Our Ref: R/4/19/HH

**Town & Country Planning Act 1990 (as amended)
Town & country Planning (Development Management Procedure) (England) Order 2015
Application for Planning Permission for Works or Extension to a Dwelling**

Development Front and rear single storey extensions and dormers to front and rear roof slopes.
Location 32 Mill Lane Rustington

PROPOSED GROUND FLOOR
1:50

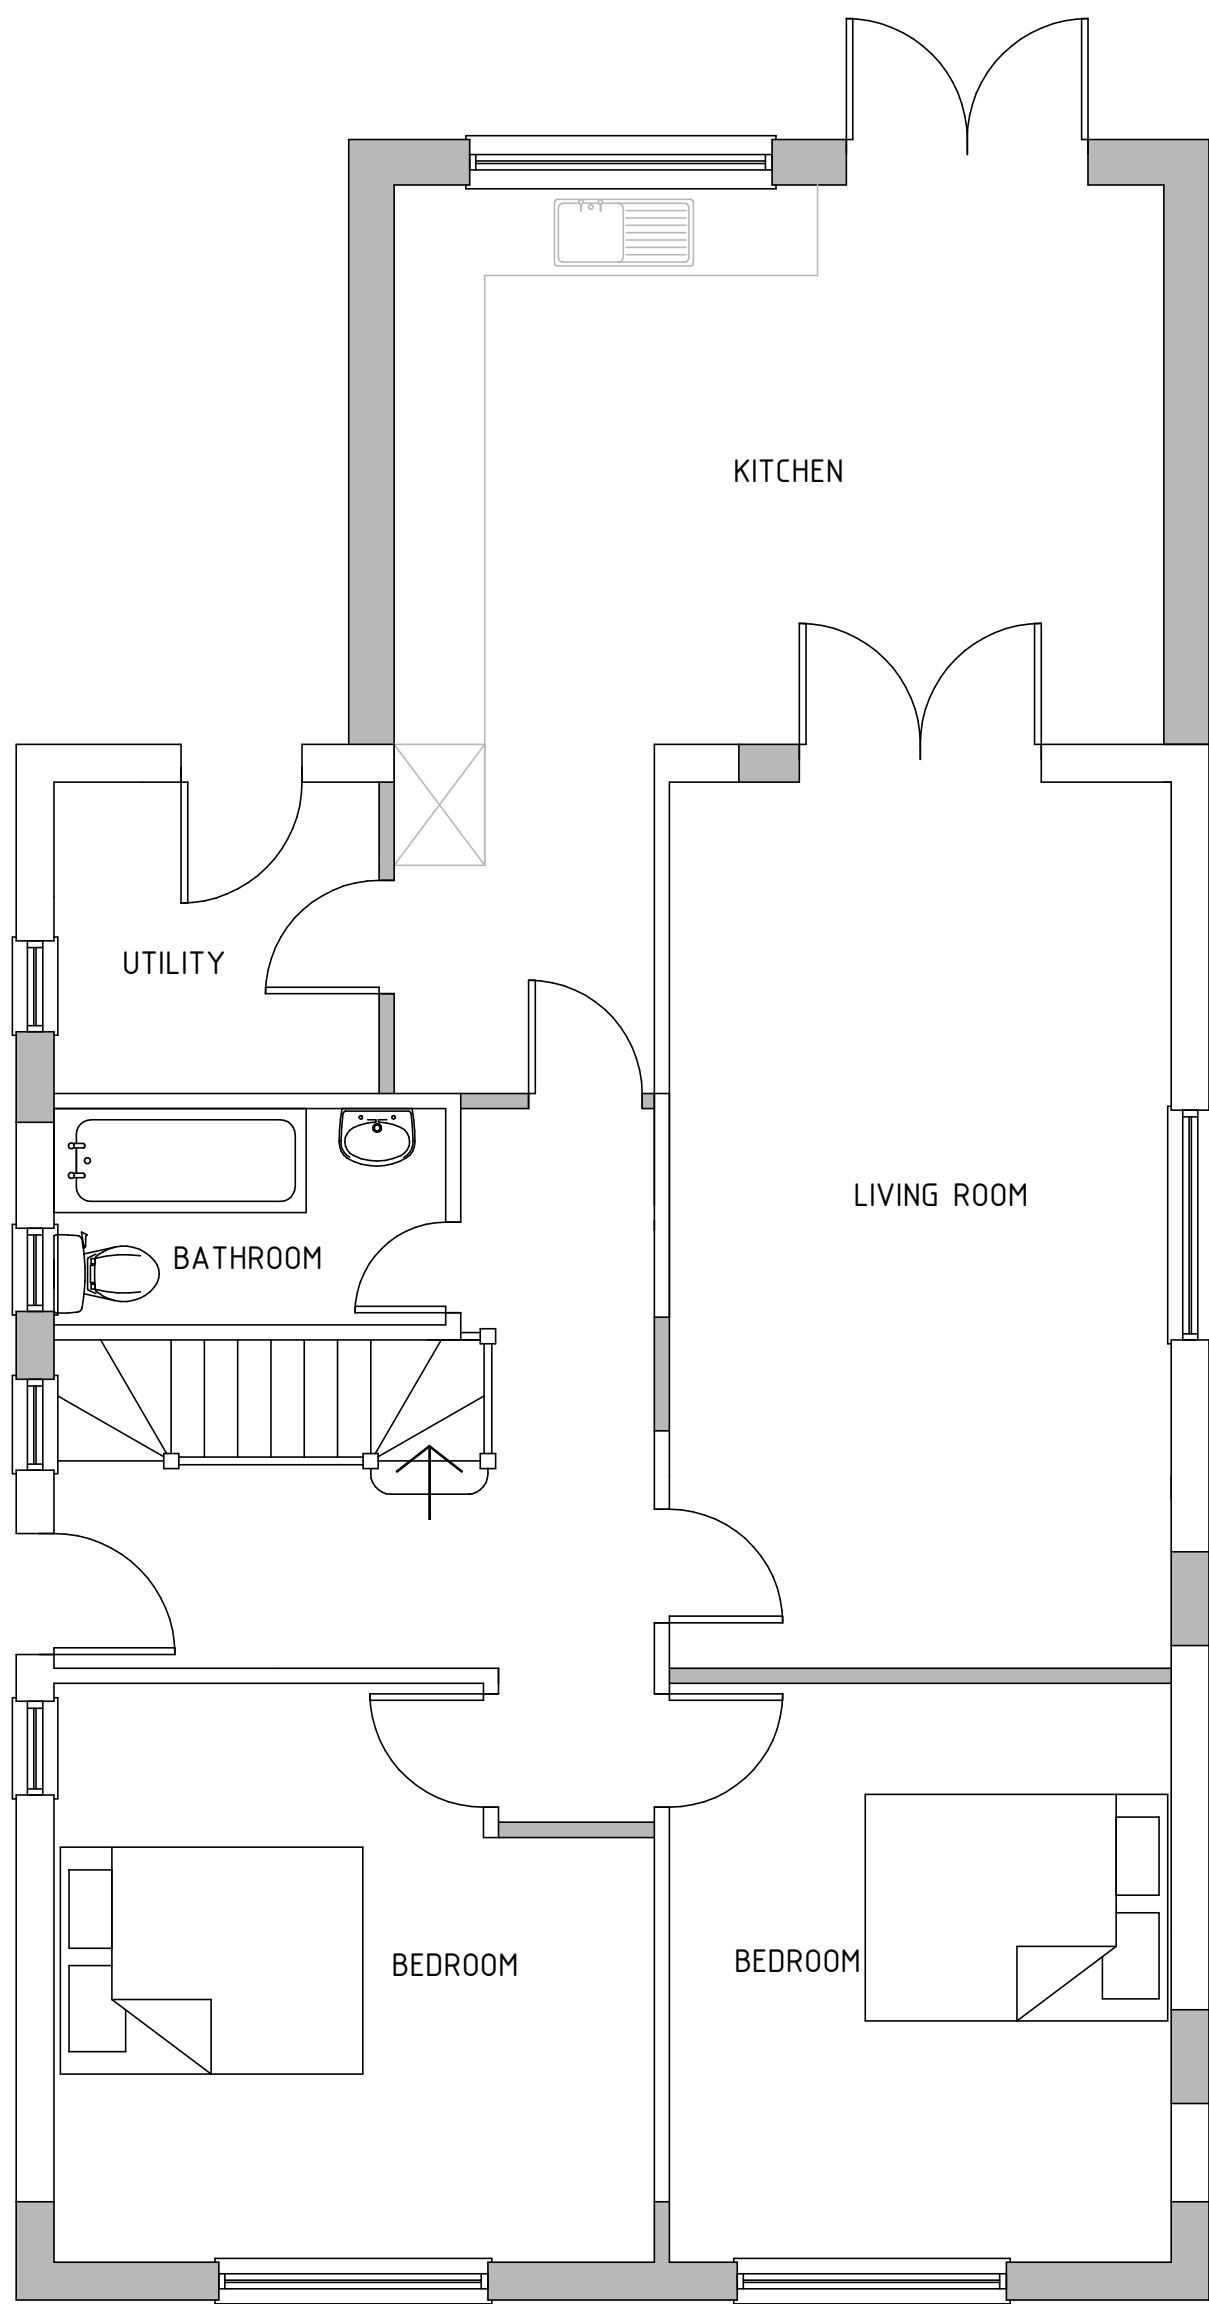
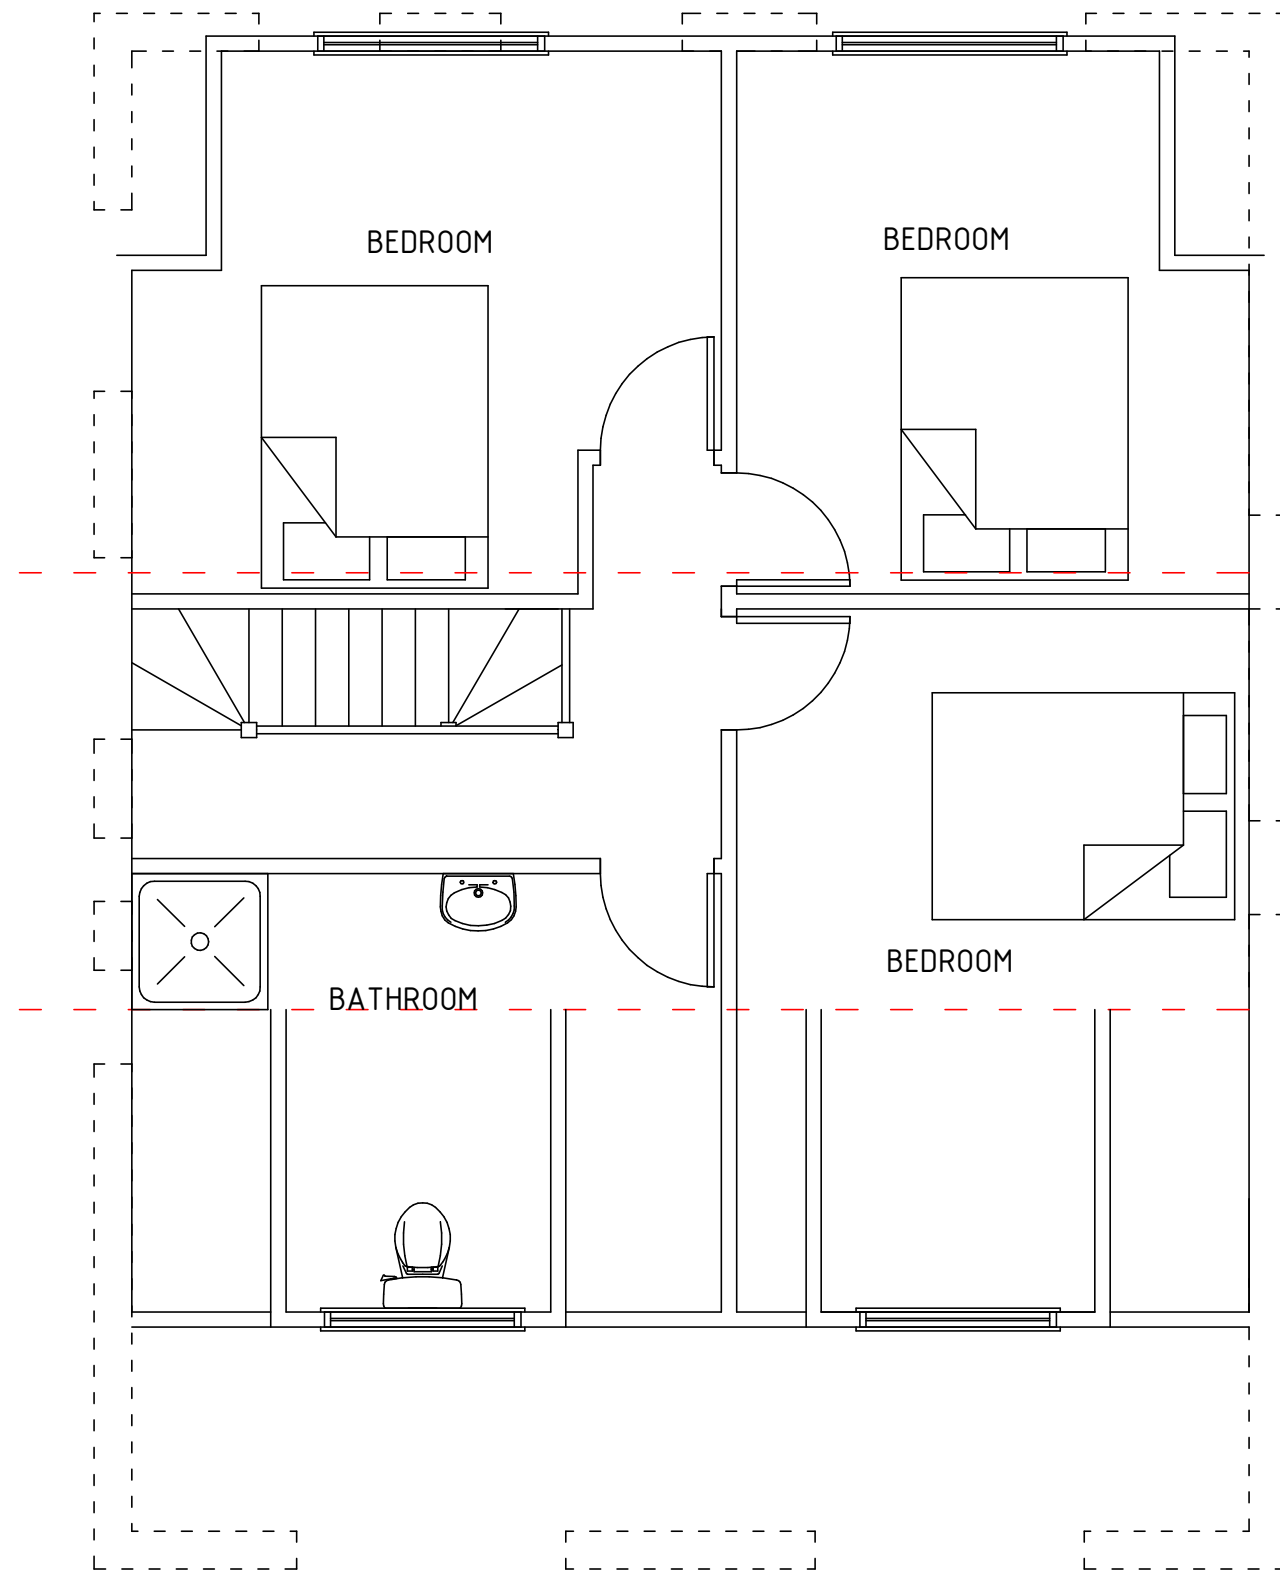
Plans Inconsistent: The windows and doors do not match between the proposed ground floor plan and rear elevation. Please amend accordingly.

Plans Inconsistent: The windows and doors do not match between the proposed ground floor plan and south elevation. Please amend accordingly.

BLOCK PLAN

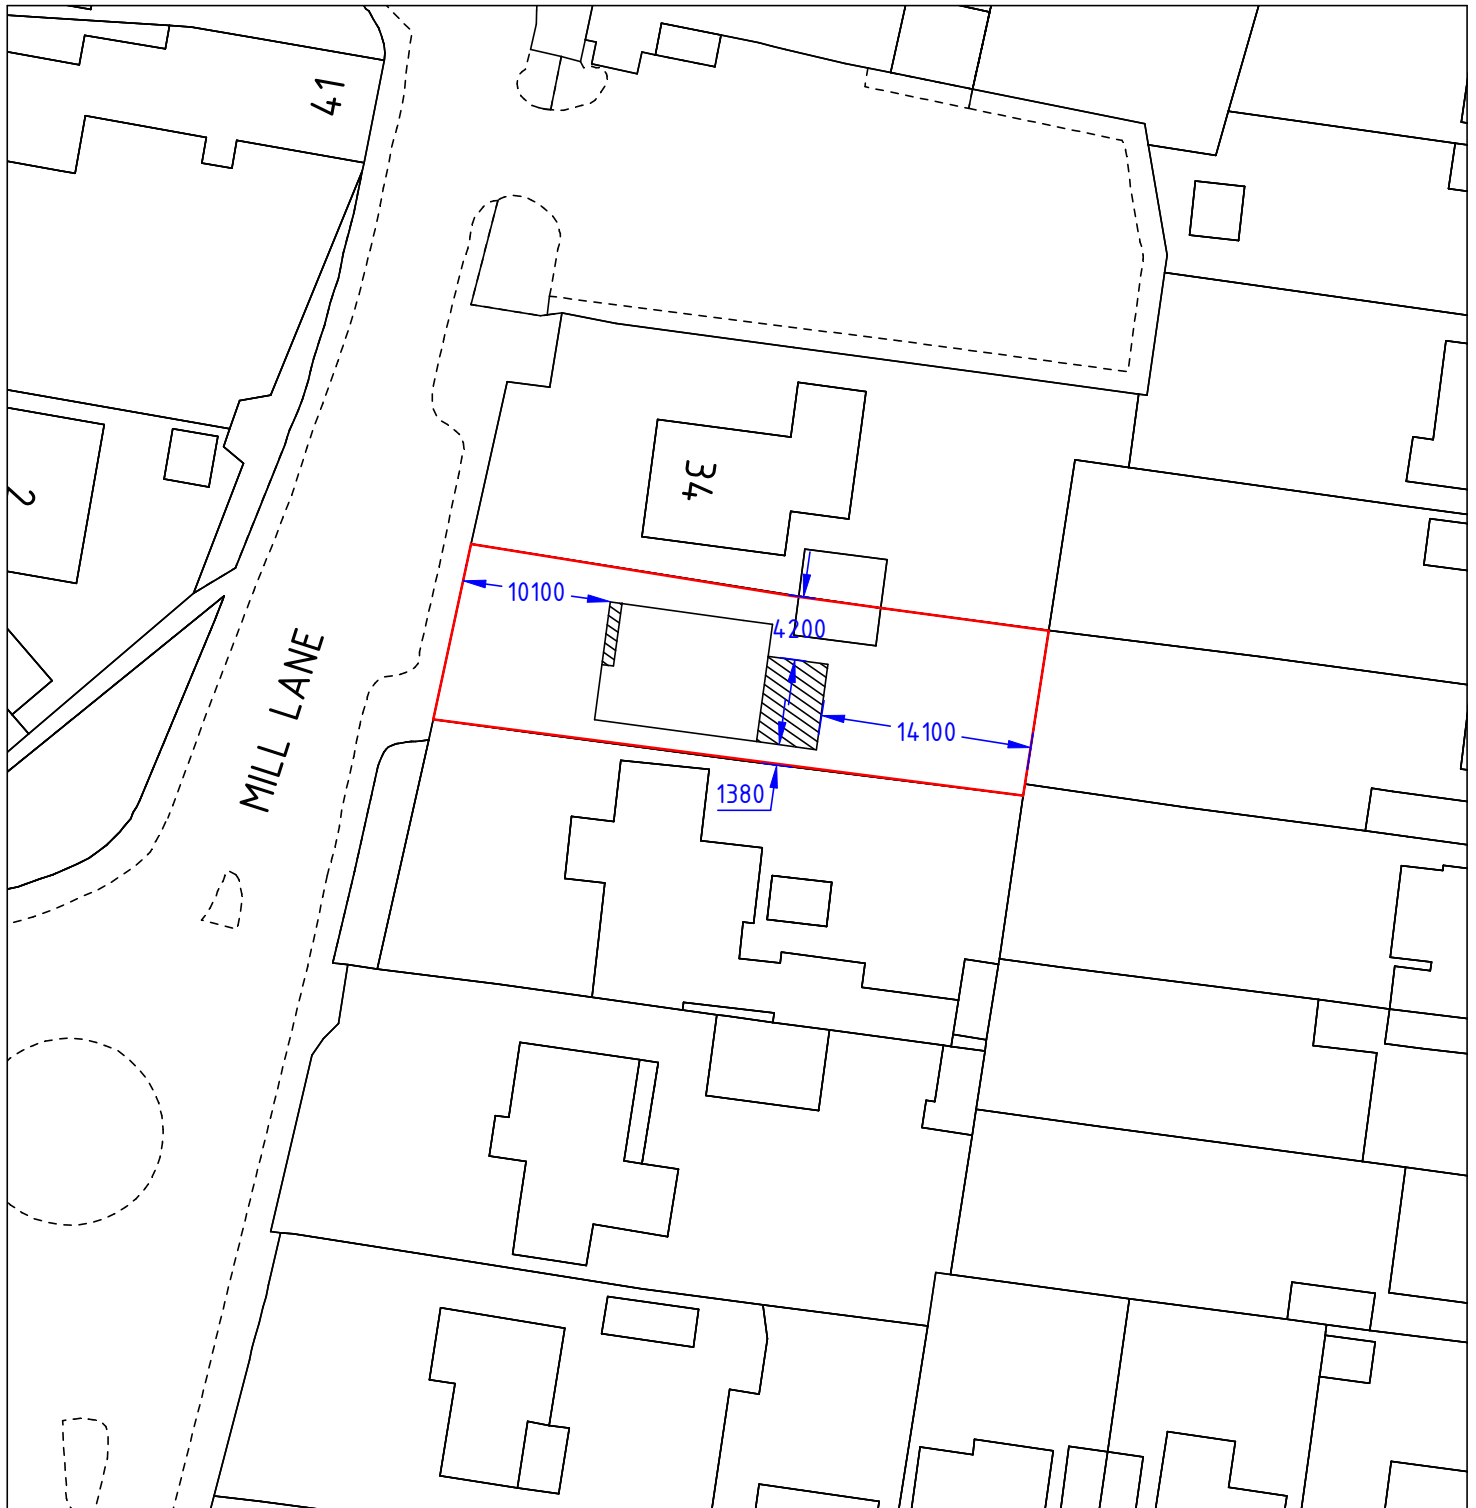
Block Plan

Please submit 1 electronic or 3 paper copies of a block/site plan which includes all dimensions from the proposed extension to all site boundaries at a scale of 1:500 or 1:200. Further details of what must be included on the plan can be found in the National Validation Requirements.
